Planning Application Reference No.: 3/2023/0573

Address of Development: Central Garage Warwick street longridge
Pr33EB

Proposed Front Elevation

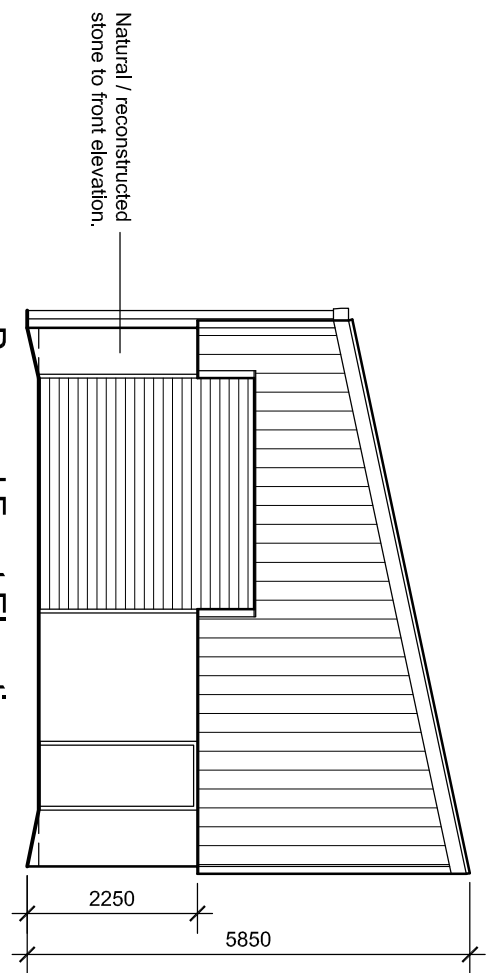
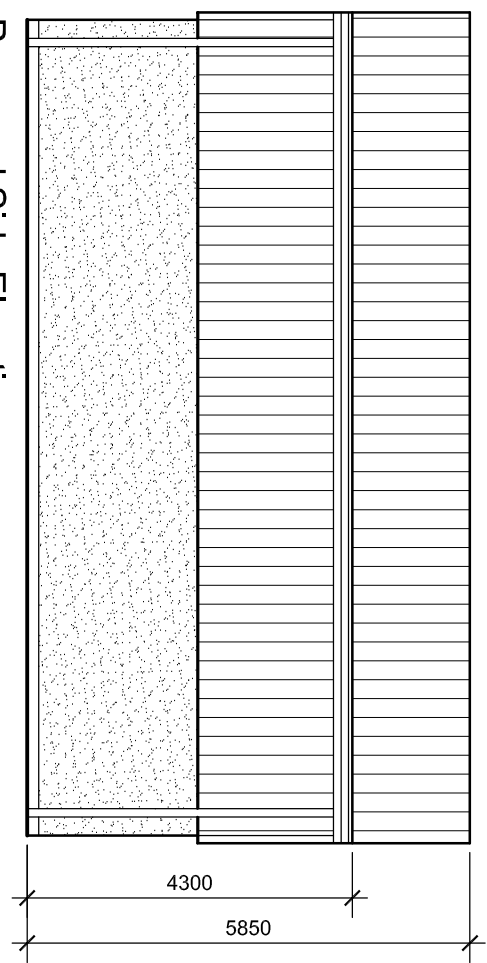
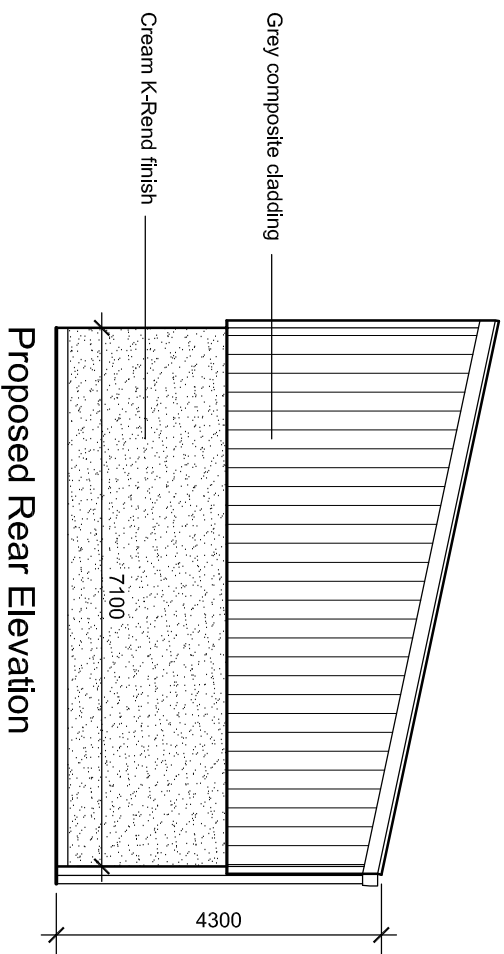
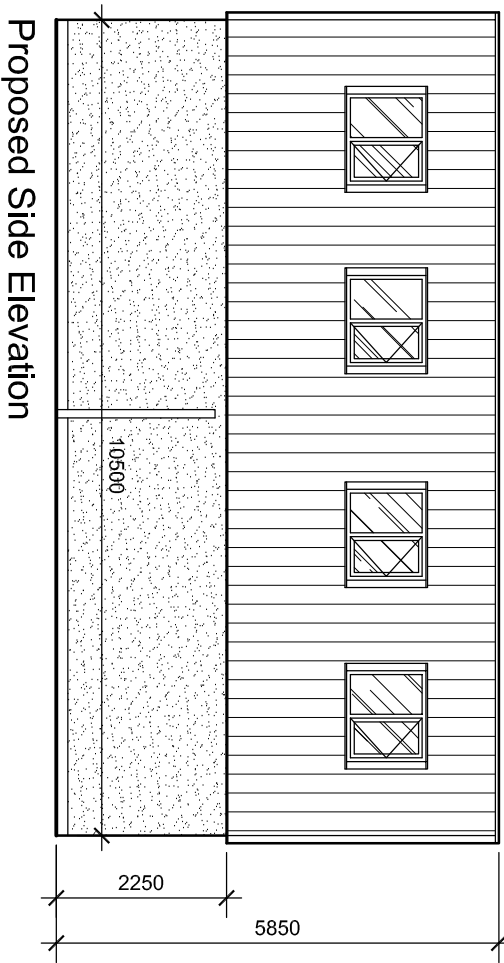
1. The proposed B2 industrial unit will be over developed for the area. It is in close proximity to a retirement complex of 9 bungalows.
2. The proposed unit will only be 6.37 metres from the bedroom windows of numbers 5, 6,&7 of the bungalows. The height of the unit will cause loss of outlook, possible loss of light and overshadowing.
3. The noise and disturbance from the industrial unit would have a detrimental effect on the well -being of the elderly residents.
4. Warwick street is already badly congested as cars are double parked along the length of the street and is quite often impassable due to delivery vehicles unloading. A further industrial unit will only add to this problem.

Proposed Ground Floor Plan

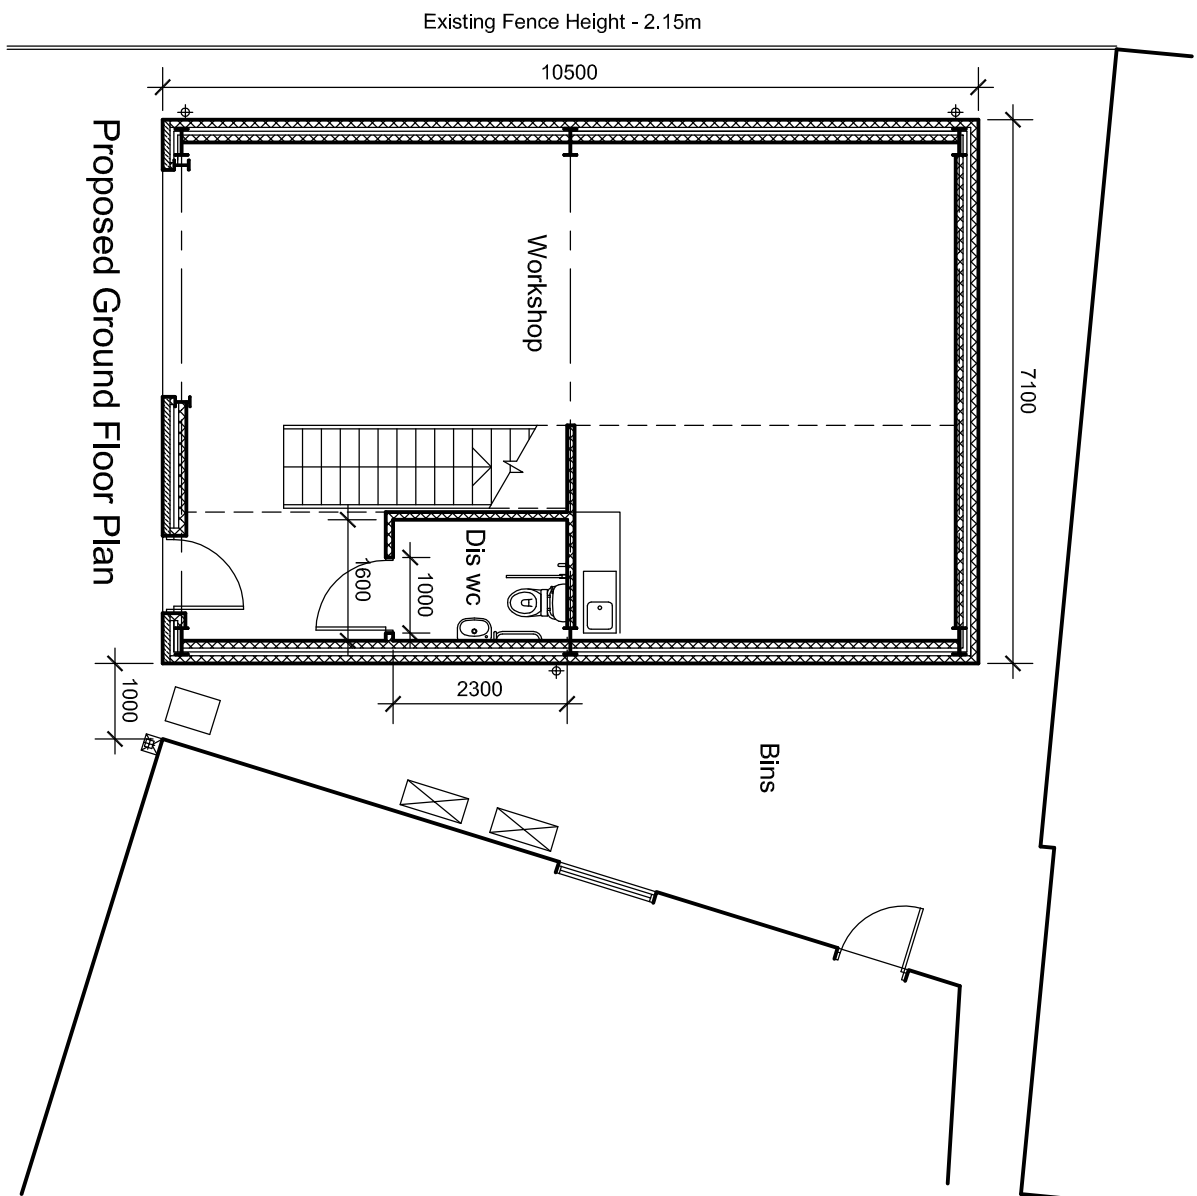
3. Size of the development. It is given that it will be 10.5 metres long and 7.1 metres wide. Having considered this and the statement that the development will stand at a minimum of 1 metre from the boundary fence of the residential properties. I am at a loss as to how this can be accommodated (7.1m), in what is very clearly a small space. I would question the validity of the given measurement, as on Google maps the site can be clearly seen with two vehicles on the site. (a normal car is of just shy of 2 metres in width). It would be posited that a third car could be accommodated but this still would only be approximately, 6 metres. So how can the site be 7.1 metres width unless it is abutting the boundary.

Proposed Site Plan 1:200

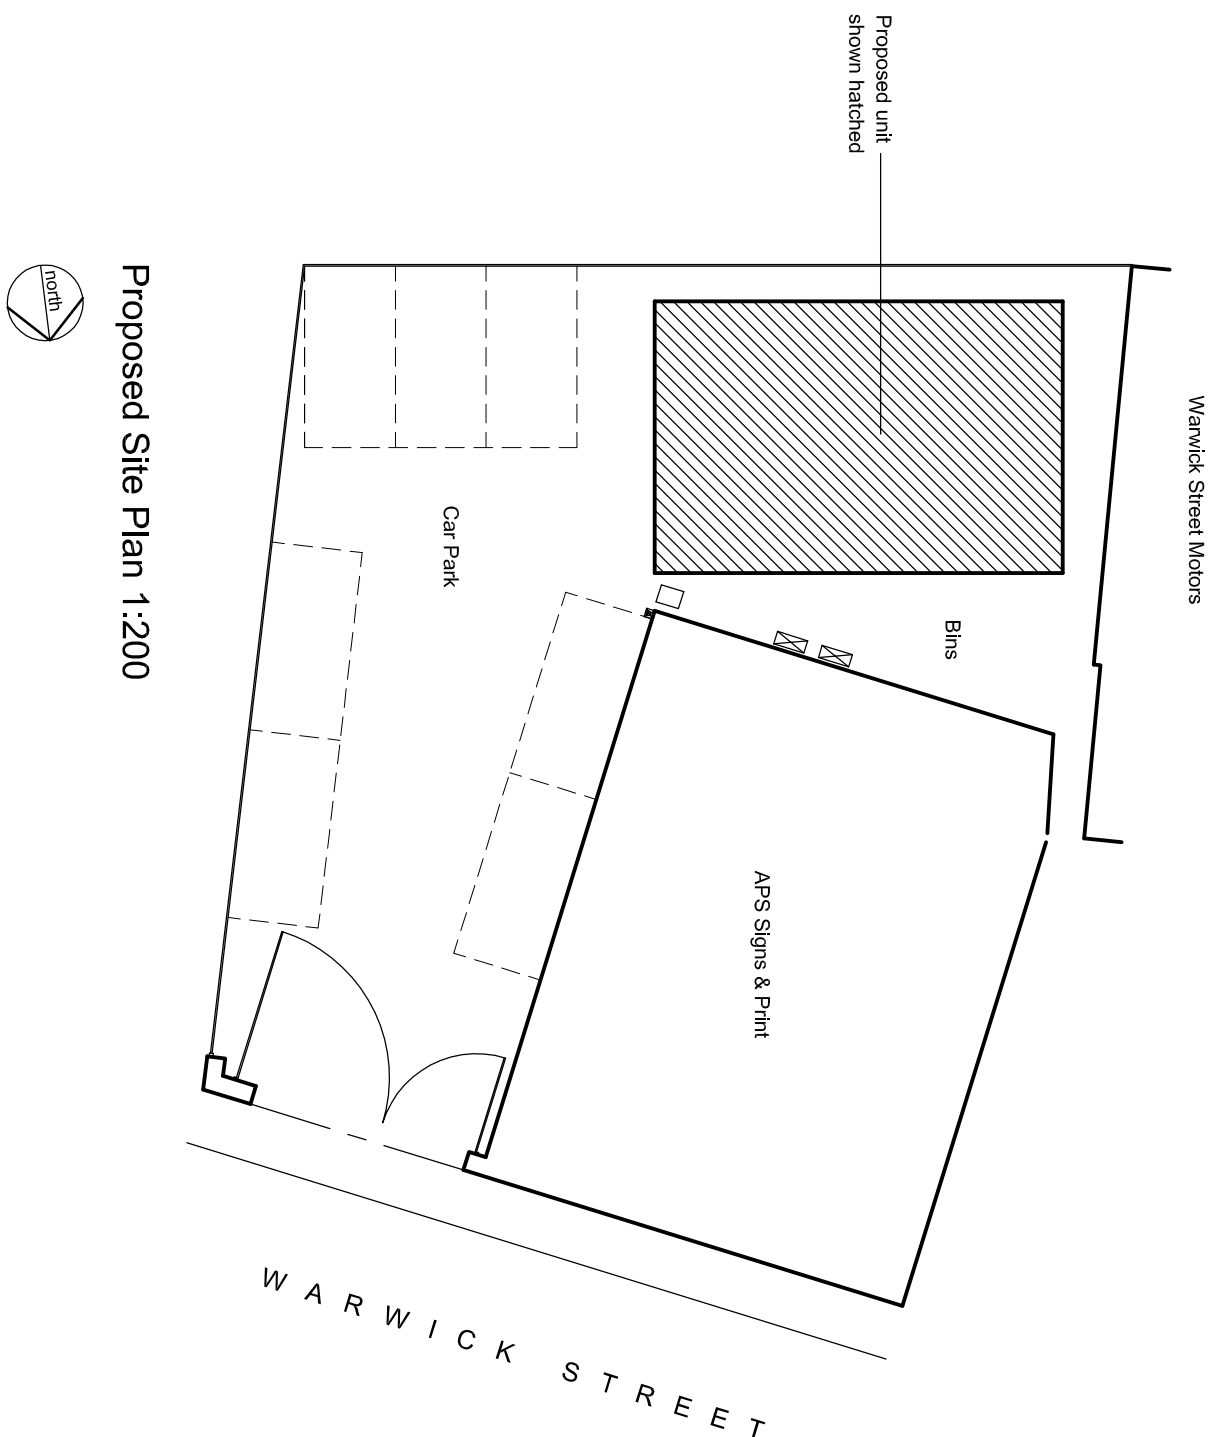
The plans include spaces for 7 Cars, but this will also include the vehicle's that access APS including the [REDACTED] so the parking would in fact be for more than one business . Is the size of the plot large enough for 7 vehicles some of which may be vans and for those using the site to turn so they do not have to reverse into a busy street and would have restricted view of oncoming traffic? Given the restrictive parking visitors may avoid the parking bays and still park on the street

The 7 spaces proposed would be for the new and current unit on the site but it would appear there is no room for maneuvering the cars which would cause further issues and visitors to the sites may avoid this and still park on the street.

Though parking spaces are to be provided these will be for the current unit and the new, are these ample and is there adequate space for the cars to turn around on site so they do not have to reverse into the street, as the view would be very restricted due to the parking around the entrance and across the road.
